# KIRKLEES METROPOLITAN COUNCIL INVESTMENT & REGENERATION SERVICE

### DELEGATED DECISION TO DETERMINE APPLICATIONS FOR LISTED BUILDING CONSENT

Reference No:	2024/65/93542/E
Site Address:	7, Eightlands Road, Eightlands, Dewsbury, WF13 2PF
Description:	Listed Building Consent for installation of replacement windows (within a Conservation Area)
Recommending Officer:	Edward Cheseldine

## **Officer Report**

Style: VICTORIAN SASH WINDOW
 Glazing: Double Glazed (Slim 4/4/4)
 Drawing: Full Section
 Scale: 1:10 @ A4

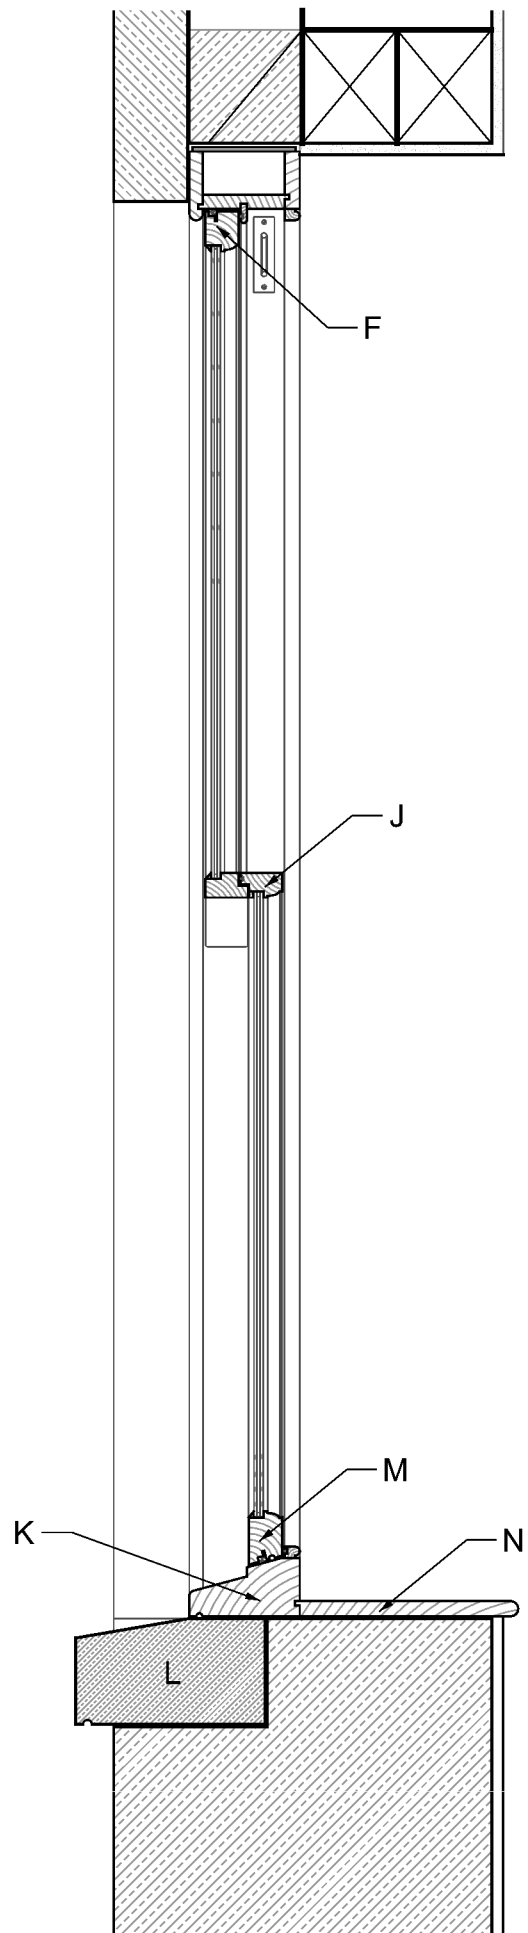
The initial windows included uPVC replacement frames. It was requested updated plans with details and sections for the timber construction were submitted.

KC Conservation & Design – Initial objection to uPVC frames. No objection to amended plans.

3. New opening windows shall be timber double-glazed sliding sashes. Joinery details shall match details in the Windows Detail Plan A101. All slim double-glazed units shall have 4mm glass with an 8mm gap with black spacer bars. Trickle vents and friction hinges shall not be permitted.
